**CITY OF MERCER ISLAND, WASHINGTON**

November 3, 2014

RE: Notice of Incomplete Application for File No. SHL14-031/SEP14-025  
9418 SE 33<sup>rd</sup> Street

PROPOSED PIER

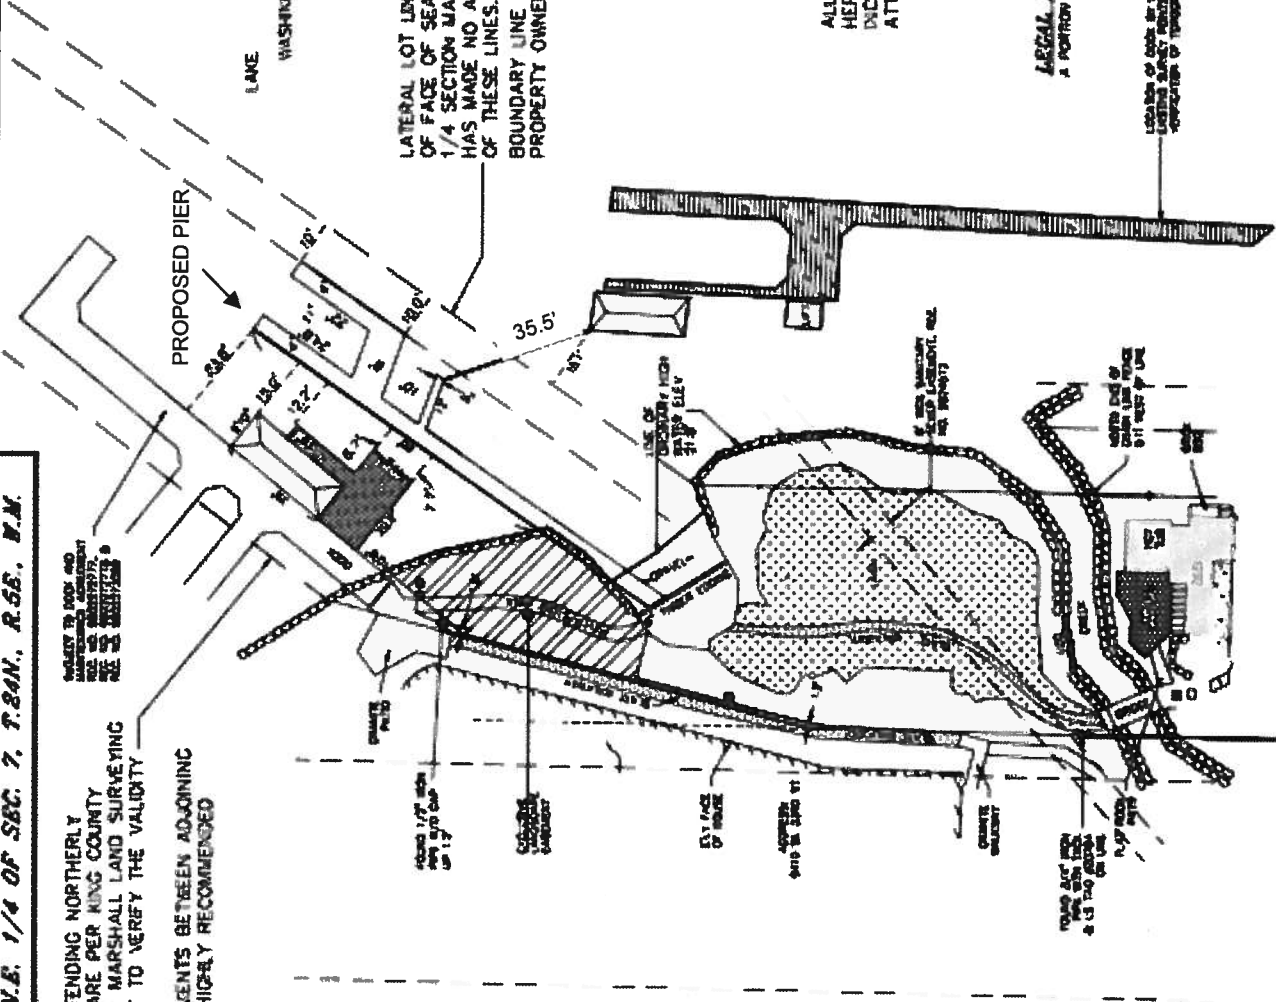
1. MICC 19.07.110(D)(2)(Table B) requires a 35 feet setback from adjoining moorage structures. The subject proposal is built within 35 feet from the moorage facility to the northeast, a joint use dock as permitted by file SHL9803-034. As detailed under MICC 19.07.110(D)(2)(Table B)(Figure B), a moorage facility may be built within the 35 feet setback subject to an agreement between adjoining owners. Please revise accordingly, or provide an agreement between adjoining neighbors.

DATE: 10/3/14 PAGE 3 OF 8

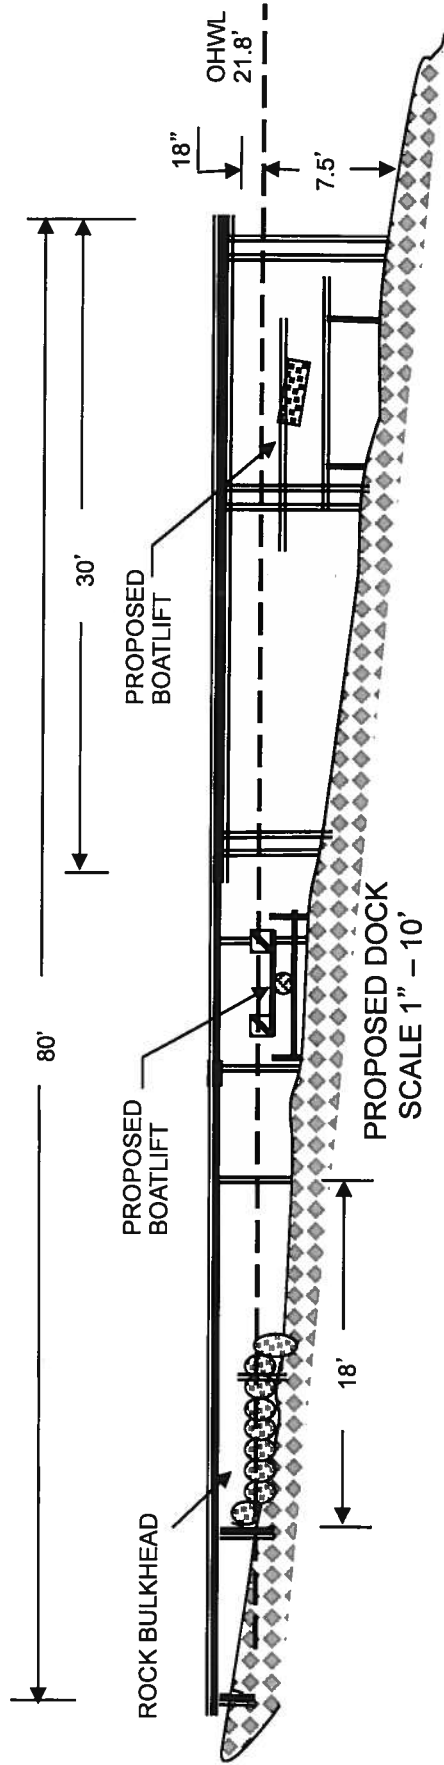
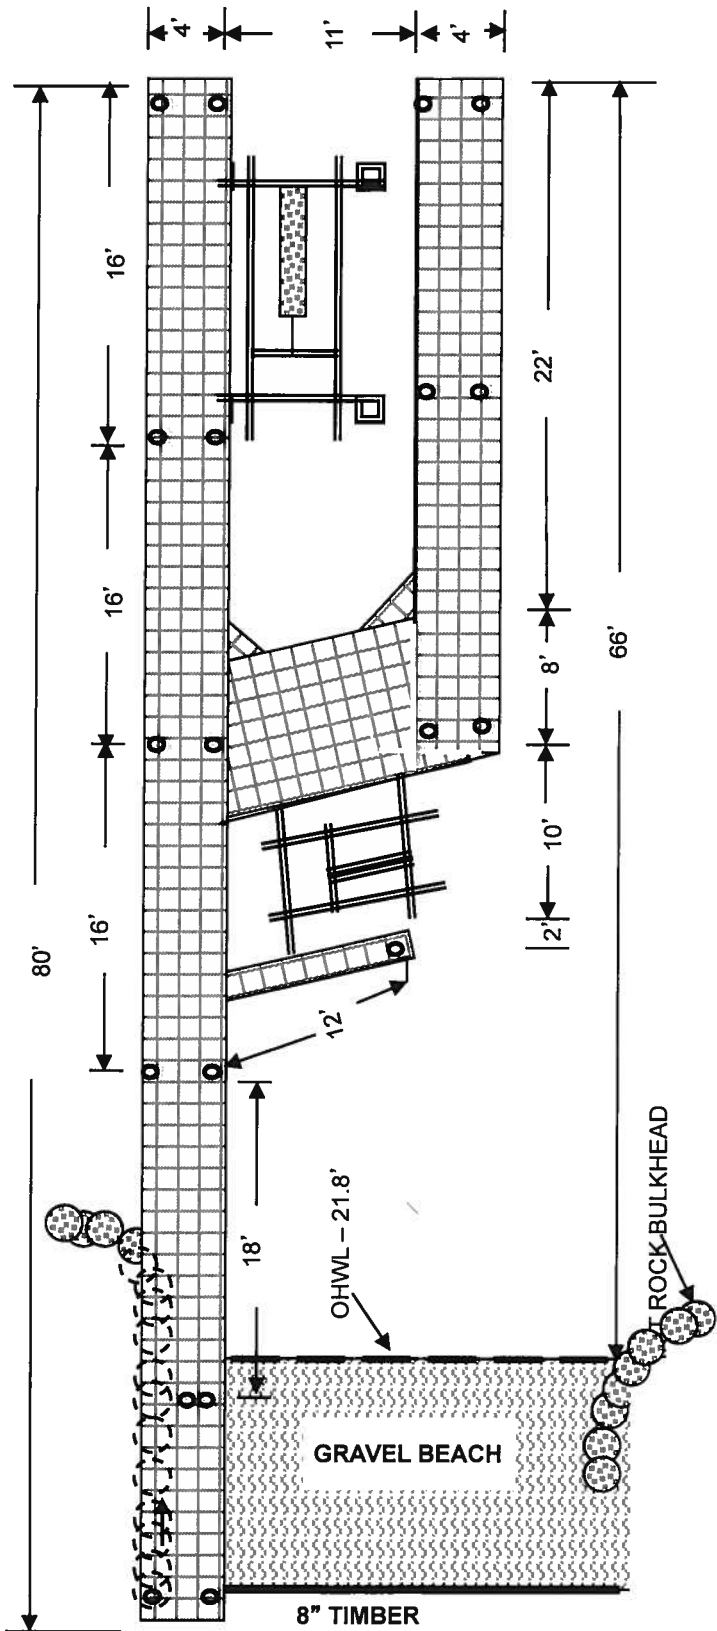
2. Pages 3, 6, and 8 of the submitted plan set are illegible. Please provide a legible plan set.
3. Survey by M.W. Marshall, Professional Land Surveyor:

4. The elevation details (page 4 of 8 of the submitted plan set) indicate that two boatlifts are proposed; however, the proposed site plan (page 3 of 8 of the submitted plan set) does not indicate any boatlifts. Please make all plan set sheets consistent.

OWN	TMM	SCALE	DATE
SVD	THAMMAM	1"=20'	9/25/14
APP'D		PAGE	SHEET NO.
		N/A	4935

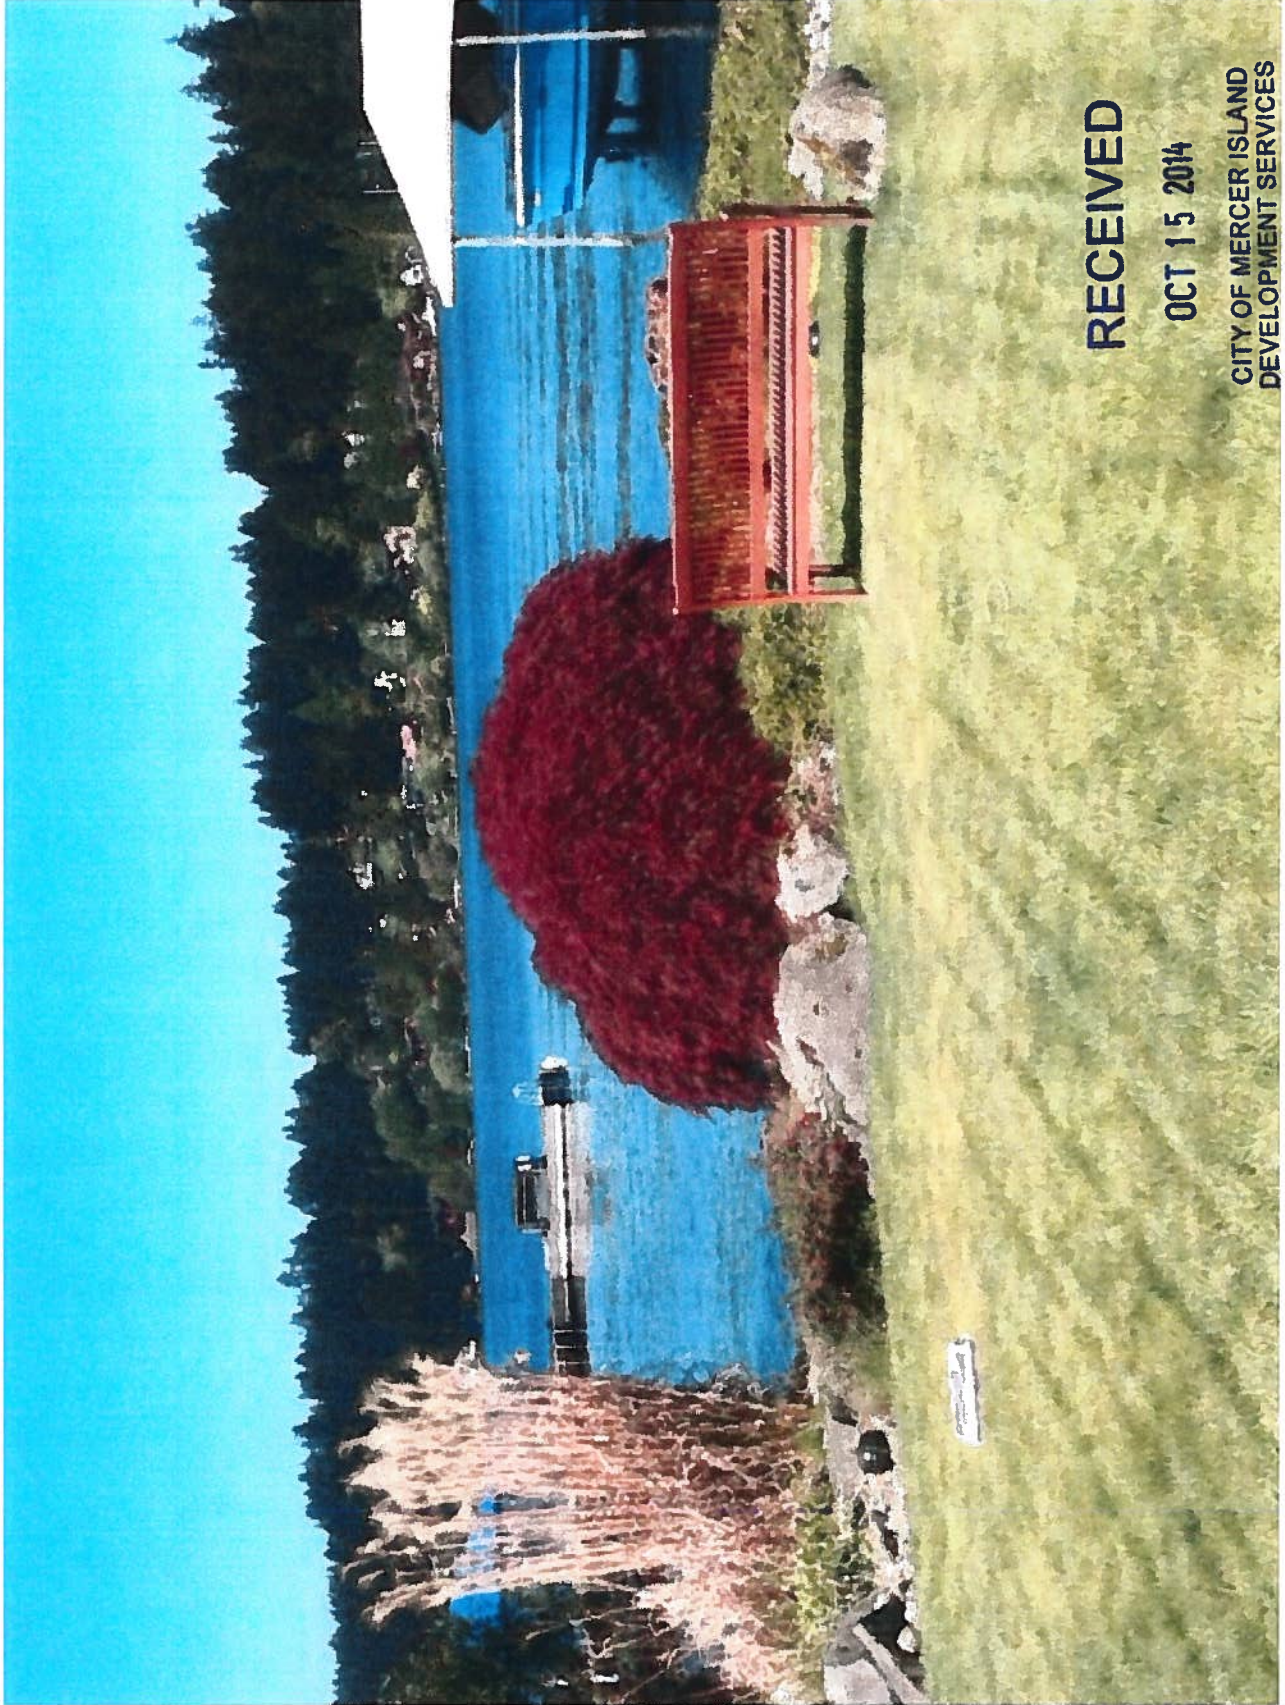
- a. The survey shows the proposed dock, which has not been constructed. Please have Mr. Marshall revise the survey so that it calls out the dock as "proposed".

- b. Please have Mr. Marshall sign the survey, as his signature is not on the provided survey.
  - c. It appears the survey was reduced to fit an 11"x17" sheet, which resulted in the survey not being to scale. Please provide a to-scale survey.
